Address: 8 Basket Lane
(Lot 18 Riverwalk submission)

C-B-L: 390-A-018
permit # 2015-01818

CHECK-LIST AGAINST ZONING ORDINANCE

Proposed Use/Work - new two story - 26' x 28' single family w/ attached 18' x 24' garage

SCALE : 1/4" = 1' - 0"

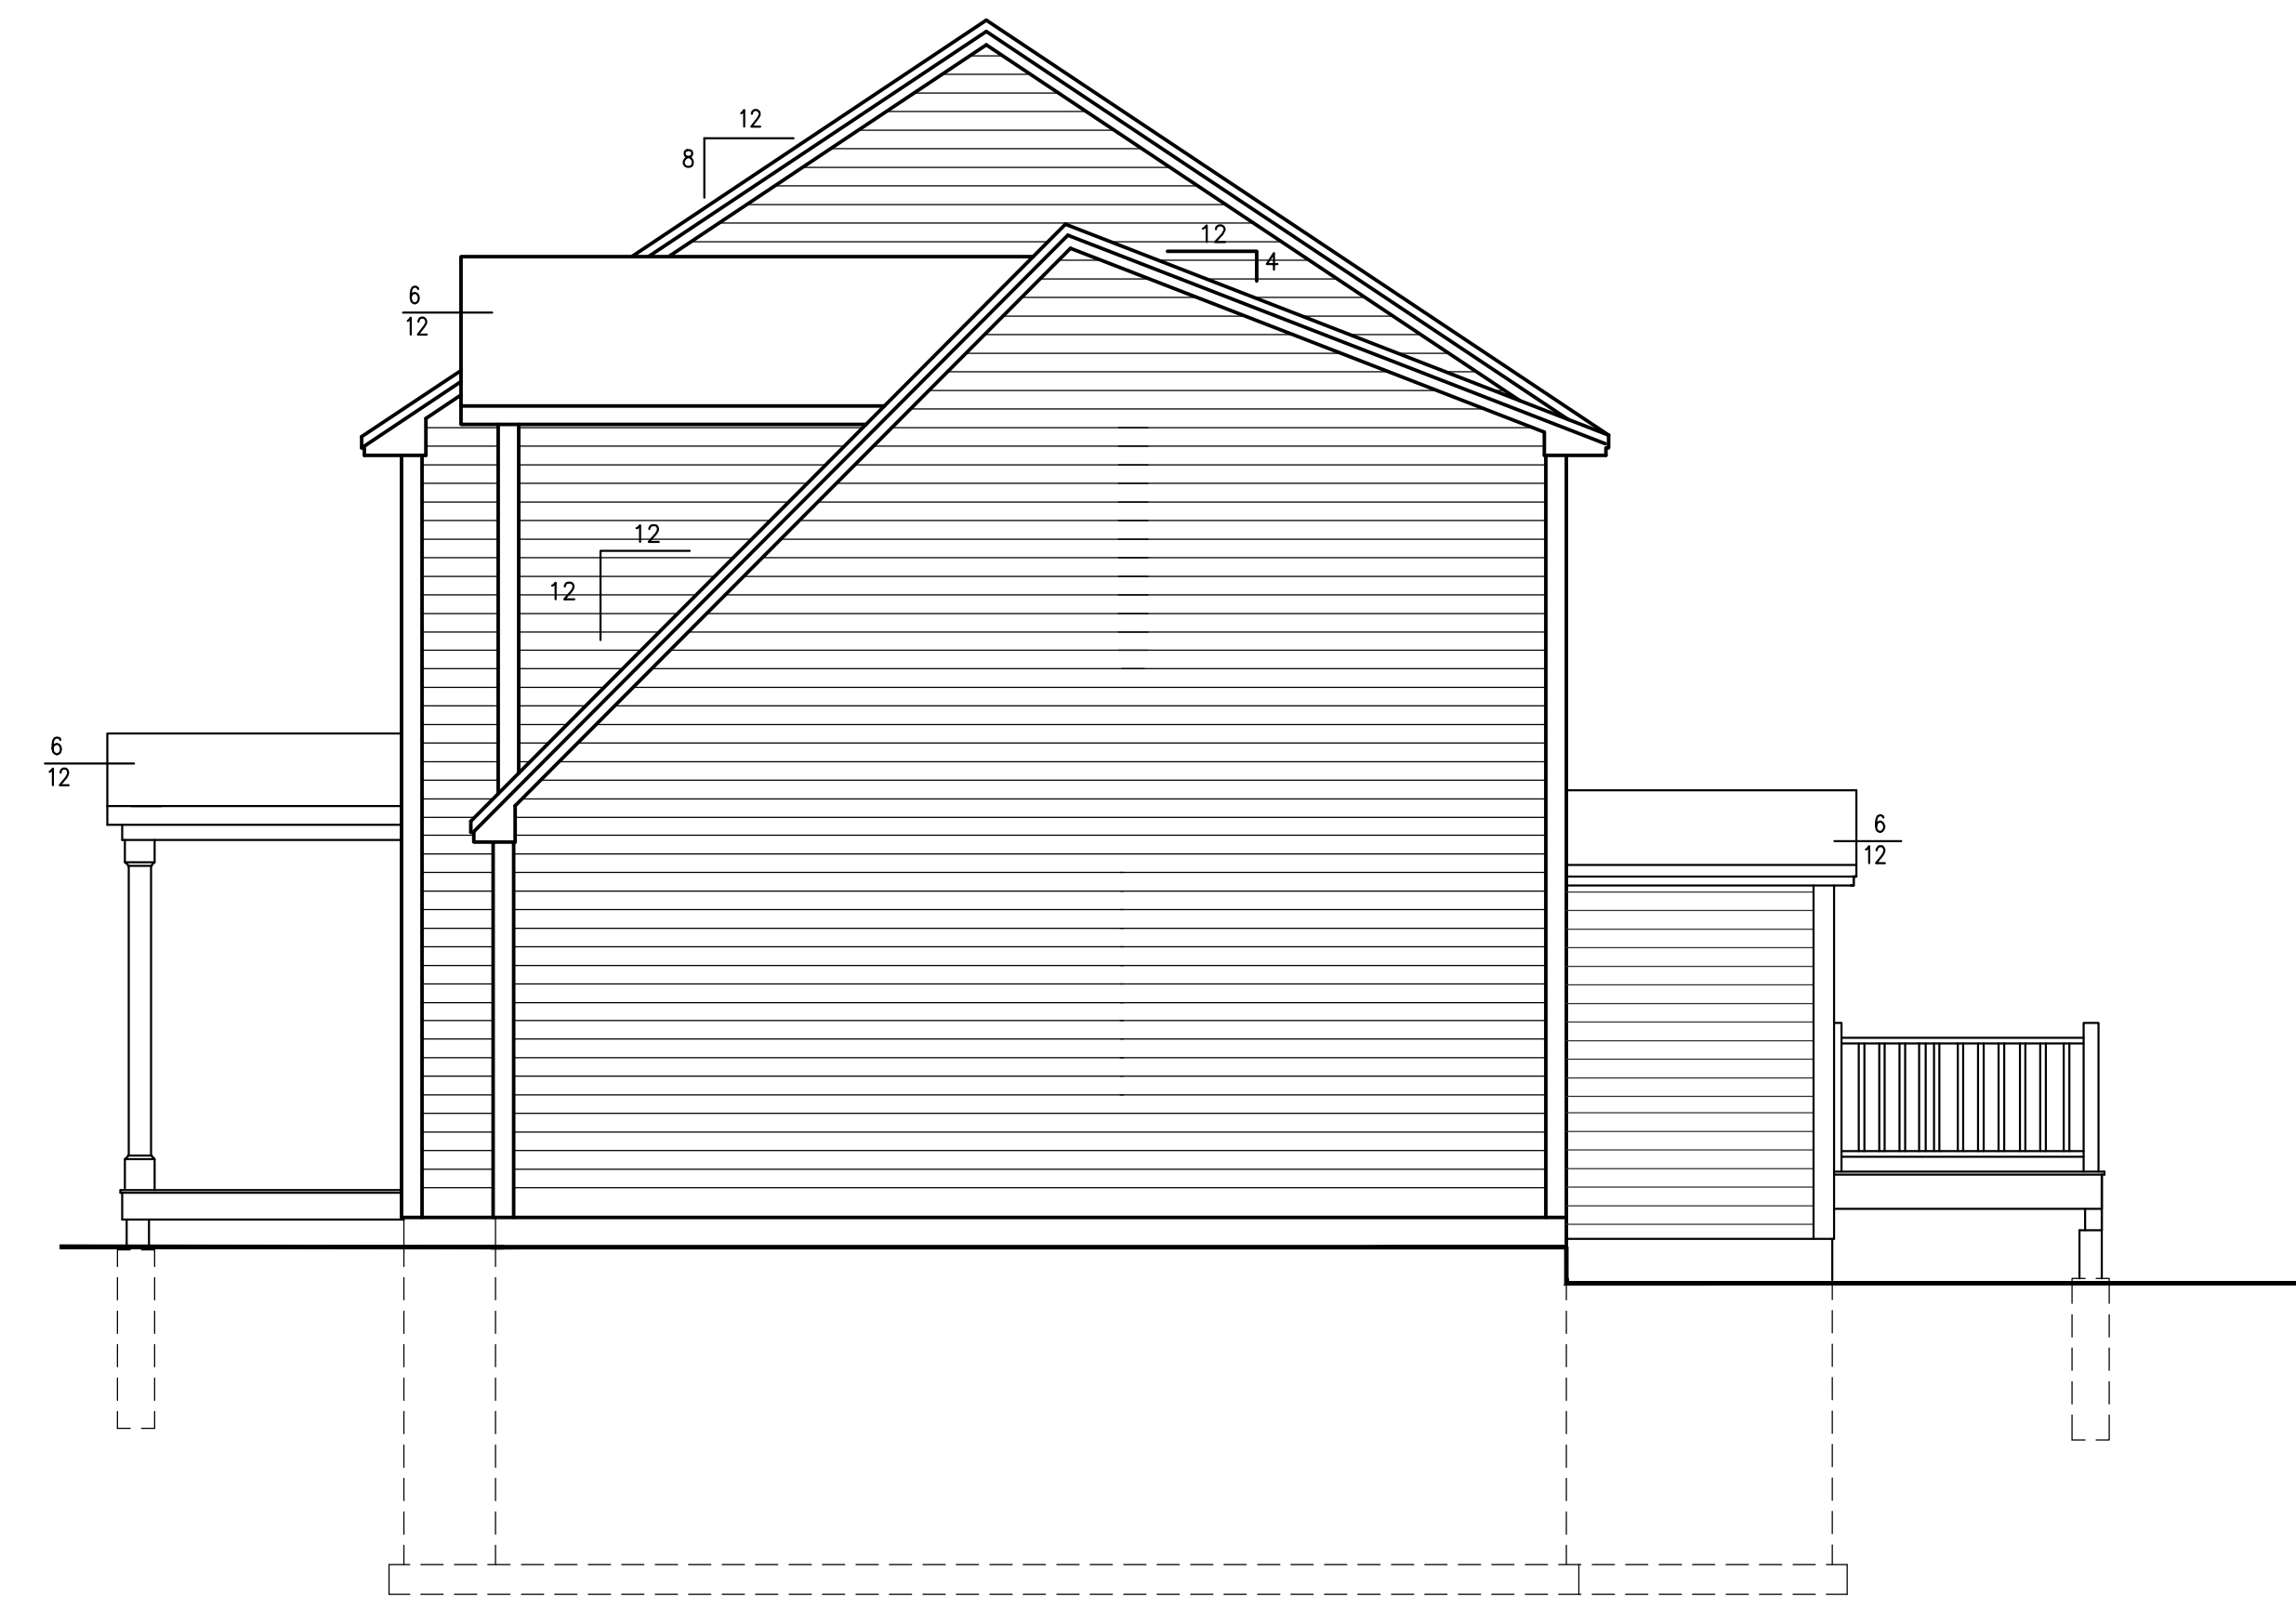
Height - 35' max - 28' setback to ridge (OK)
